DRB CASE ACTION LOG - BLUE SHEET

Project #: 1002701 Application #: 14DRB-70070
 Project Name: North Alb Acres
 Agent: Rmkm Architecture Phone #:

Your request was approved on 3-19-14 by the DRB with delegation of signature(s) to the following departments - outstanding comments to be addressed

A0.10

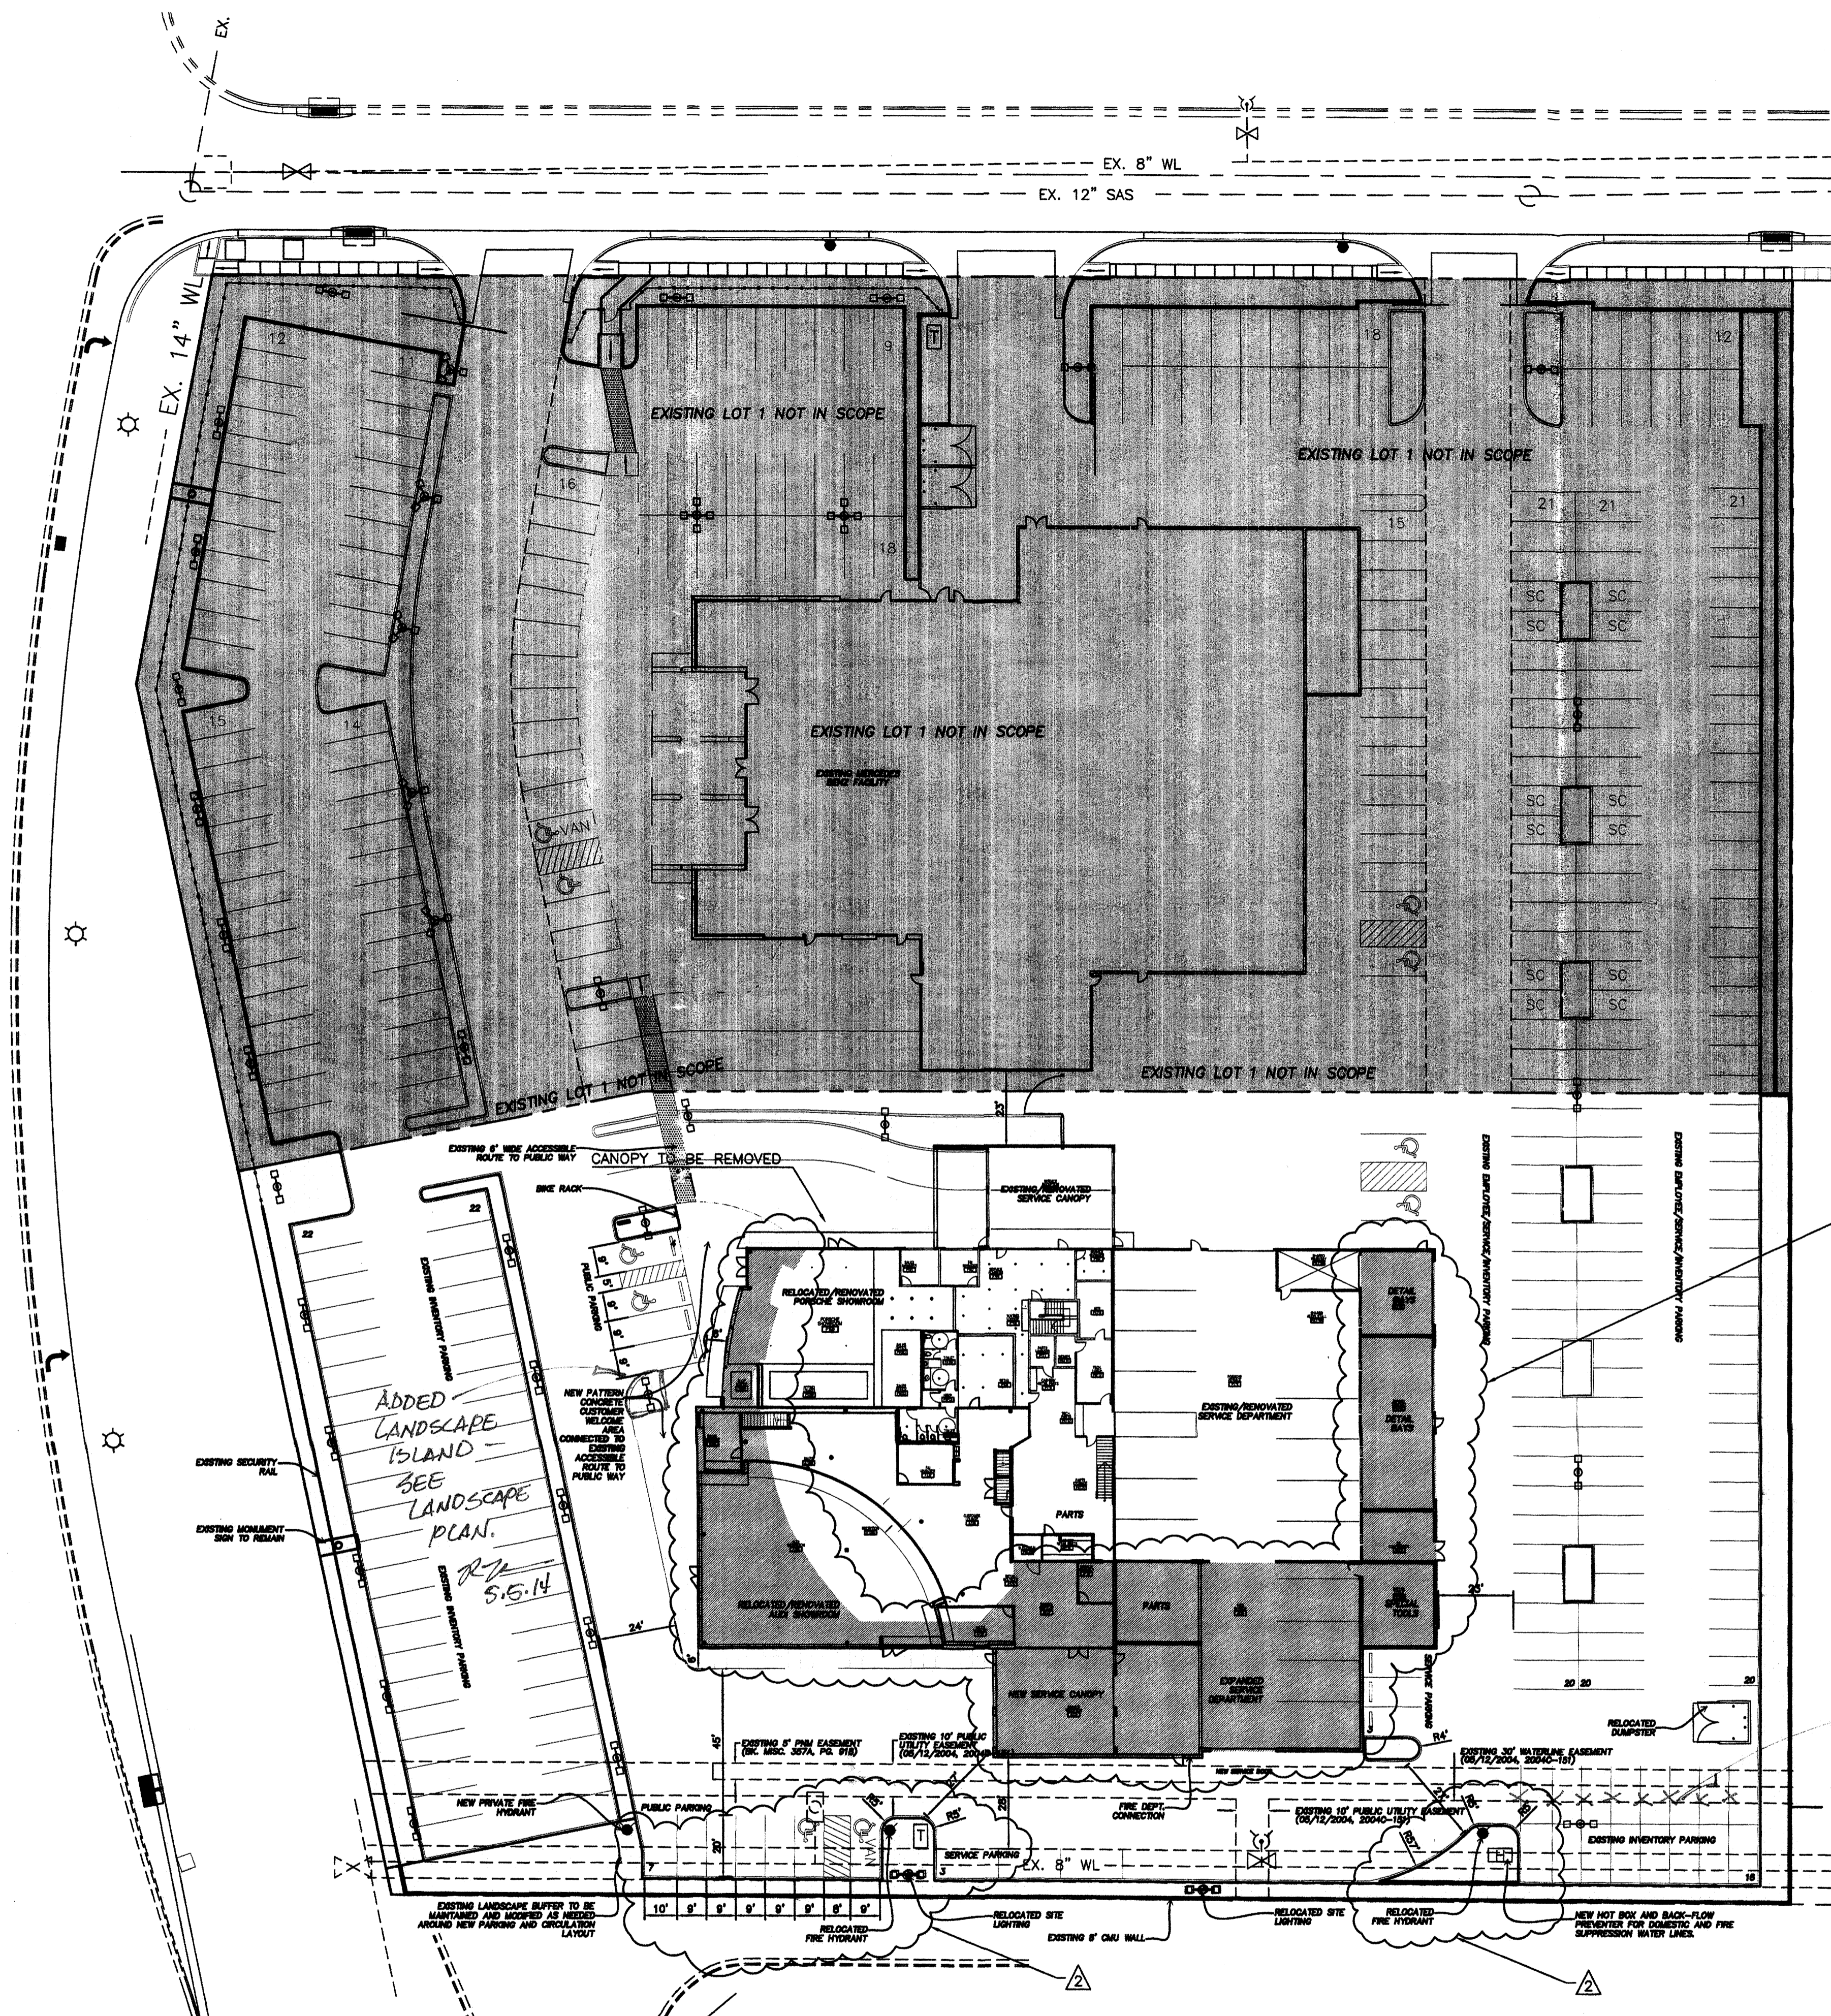
PLANNING (Last to sign): - add'l landscaping, revise parking
 Off Zoning Enforcement table
